Appeal Decision

Appeal Ref: APP/R5510/D/24/3345547

112 Swakeleys Road, Ickenham, Hillingdon UB10 8BA

- The appeal is made under section 78 of the Town and Country Planning Act 1990 (as amended) against a refusal to grant planning permission.
- The appeal is made by Mr A Garg against the decision of the Council of the London Borough of Hillingdon.
- The application Ref is 41605/APP/2024/302.
- The development proposed is described as 'to increase side dormers by 2m'.

CLIENT
MR & MRS GARG
PROJECT
112 SWAKELEYS ROAD
DESCRIPTION
PROPOSED RIGHT & LEFT ELEVATION
SCALE DRAWN BY DATE
1.50 RJ 17.12.23
DRAWING NO. **REVISION**
100_09 X

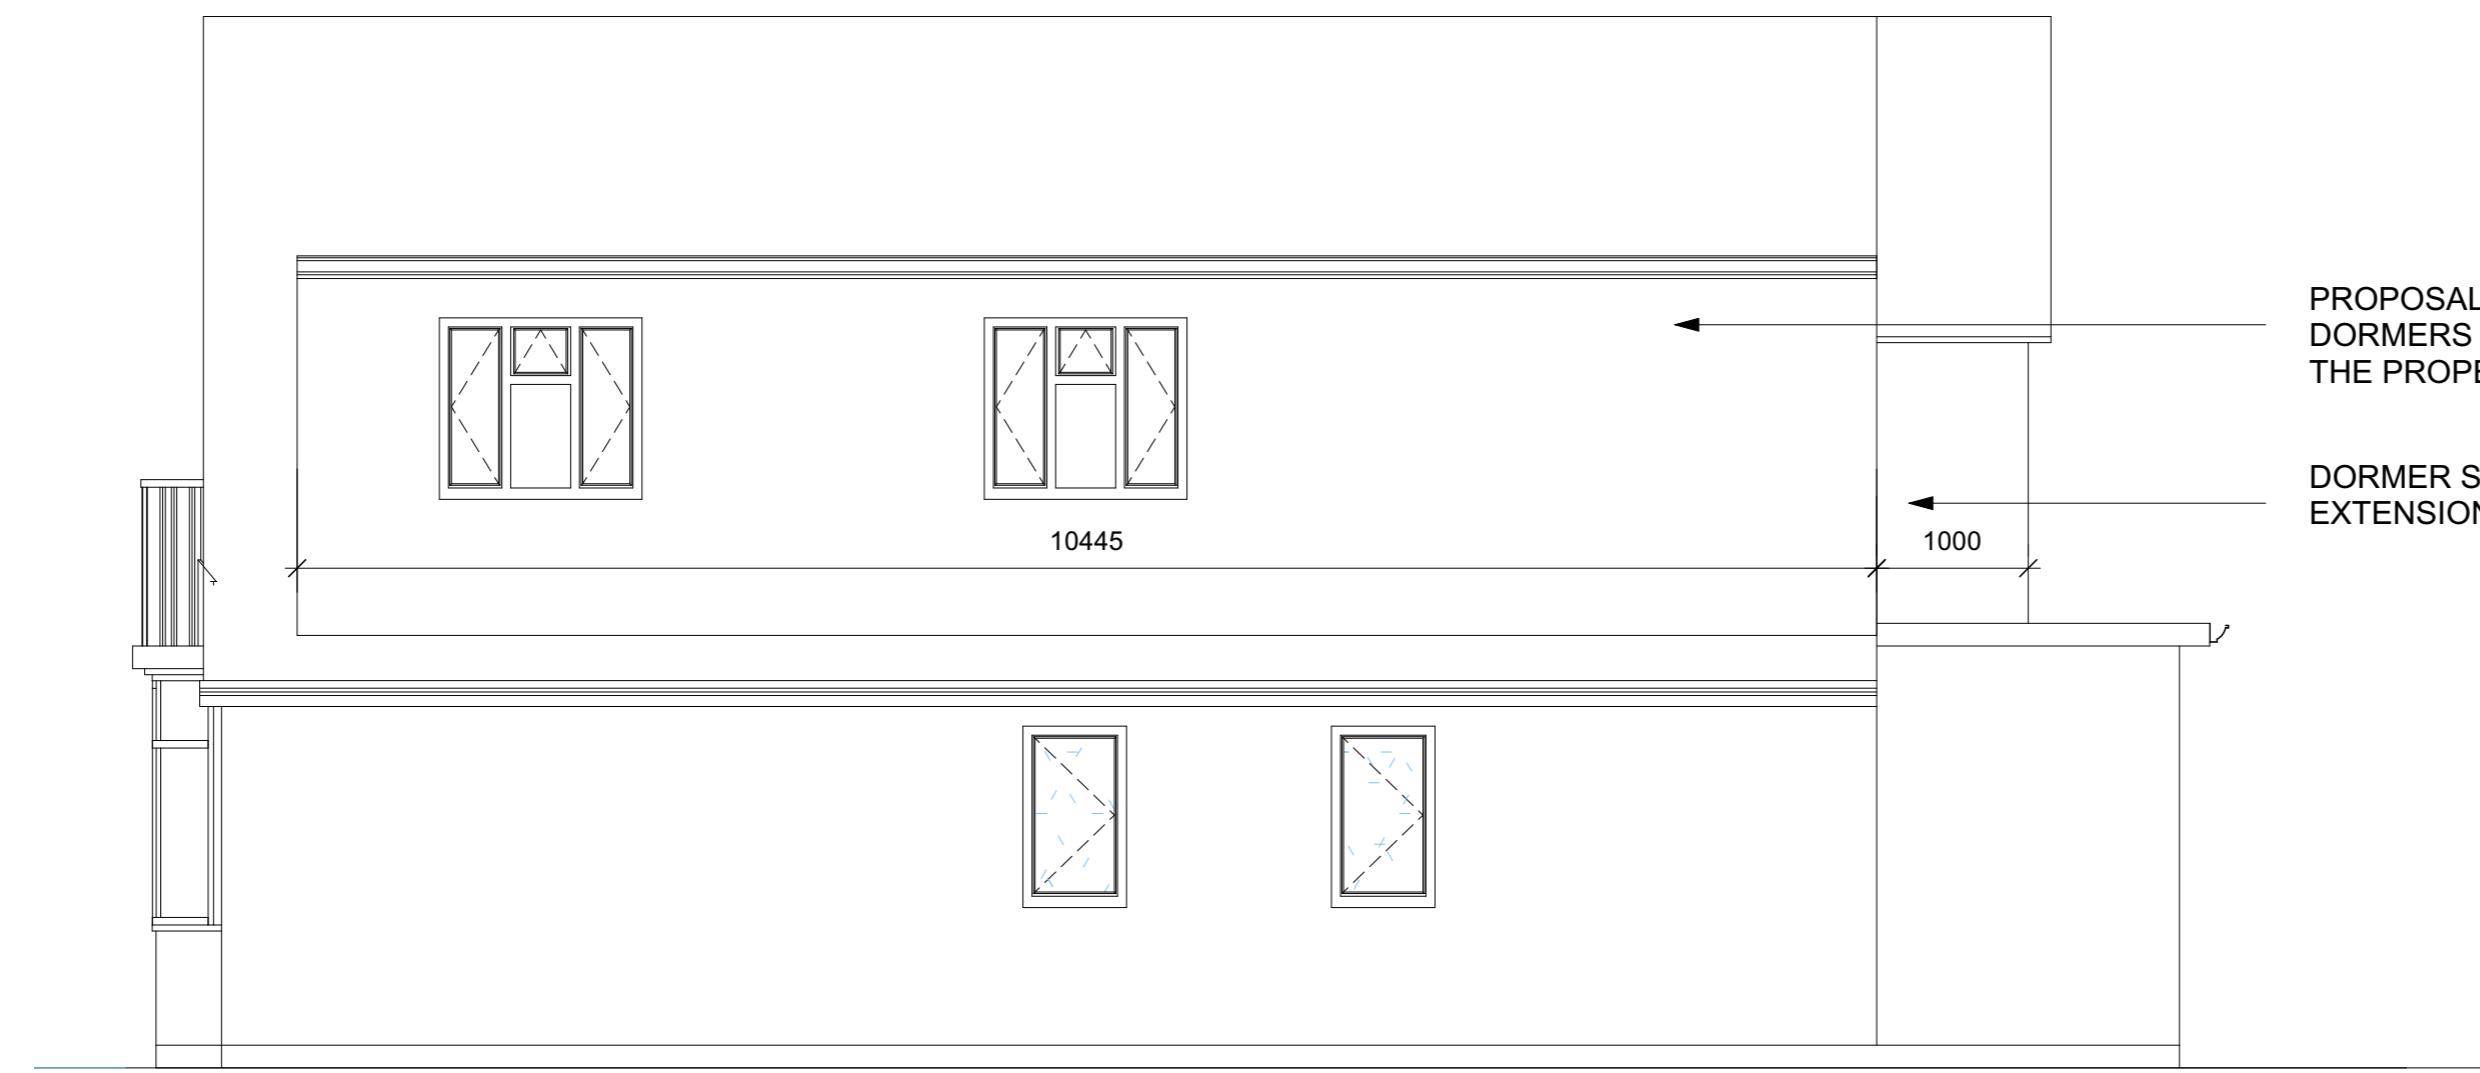
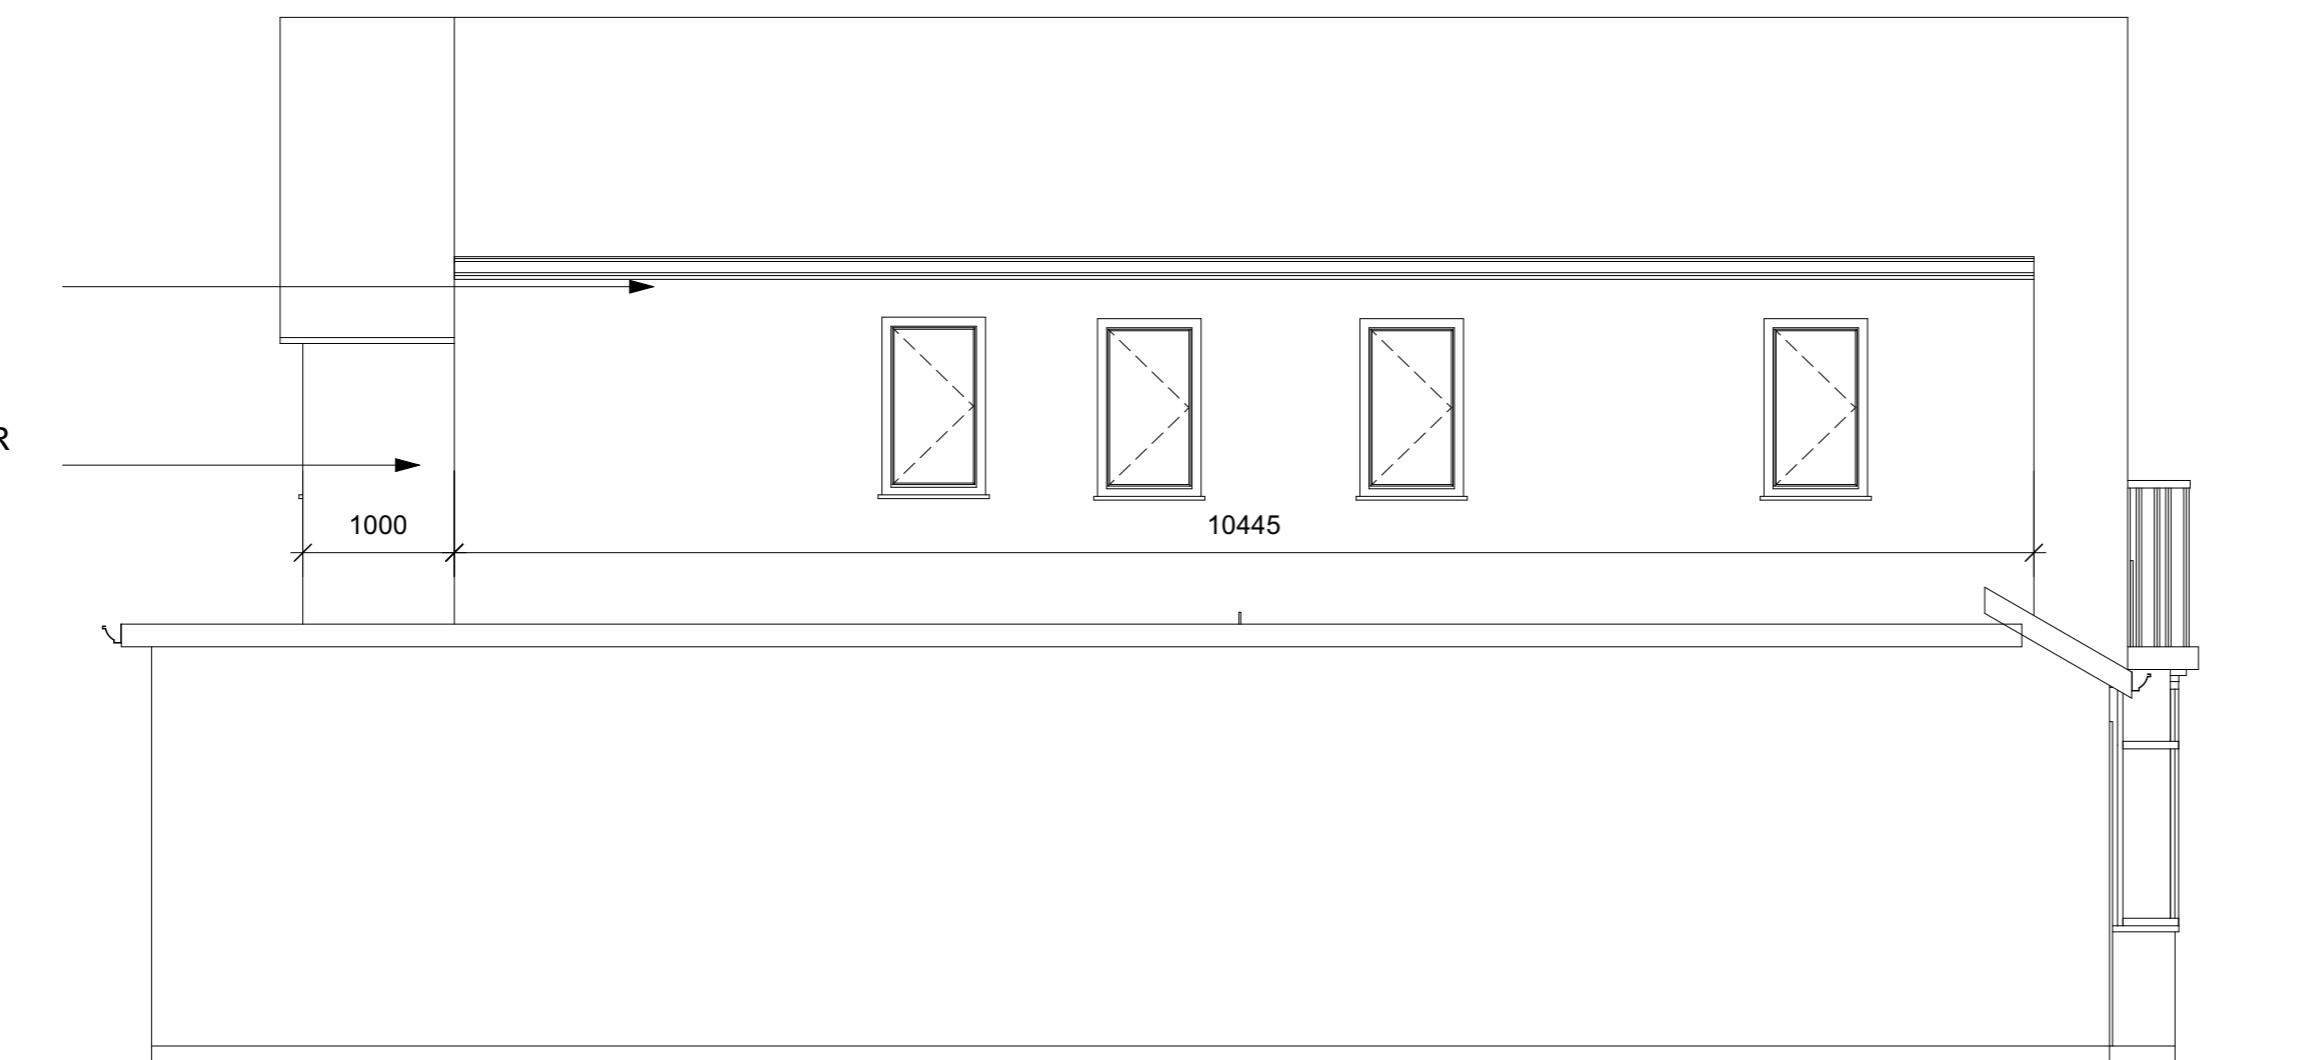
3. Planning permission was granted for a similar development to that described by the Council. The appellant now seeks to increase the length of the side dormer windows by a further 2m towards the rear. As there are no objections to any other aspects of the appeal proposal, this decision focuses only on the issue in contention. The main issue in this appeal, therefore, is the effect of the proposed increase in the length of the proposed dormers on the character and appearance of the host property and the surrounding area.

5. The extended dormers would be located below the ridge tiles, an element of the original and extended roof slopes above the eaves line would be retained and they would be set in 1m from the rear elevation of the first-floor extension. The dormers would therefore remain within the roof profiles. The additional length of the dormers would be proportionate to the size of those that have previously been approved and would be proportionate to the bungalow as it would be extended. The larger dormers would be sufficiently subservient to the scale of the existing roof.

6. No 114 Swakeleys Road (No 114) projects about 2m further forwards than No 112. This creates a staggered building line in which the flank elevation of No 112 is largely screened by the massing of No 114. The rearmost part of the already approved dormer windows would be screened from public views due to the orientation of the bungalows and the road. It follows therefore that views of the additional dormer length towards the rear of the building would also be limited. But in any event, whilst the bulk and mass of No 112 would increase, the proposed development would not appear incongruous in the context of the neighbouring bungalows, despite the differing length of their dormers.

- 5) The side facing dormer windows facing No. 110 and No. 114 shall be glazed with permanently obscured glass to at least scale 4 on the Pilkington scale and be non-opening below a height of 1.8 metres taken from internal finished floor level for so long as the development remains in existence.
- 6) Access to the flat roof over the extension hereby approved shall be for maintenance or emergency purposes only and the flat roof shall not be used as a roof garden, terrace, balcony, patio or similar amenity area.
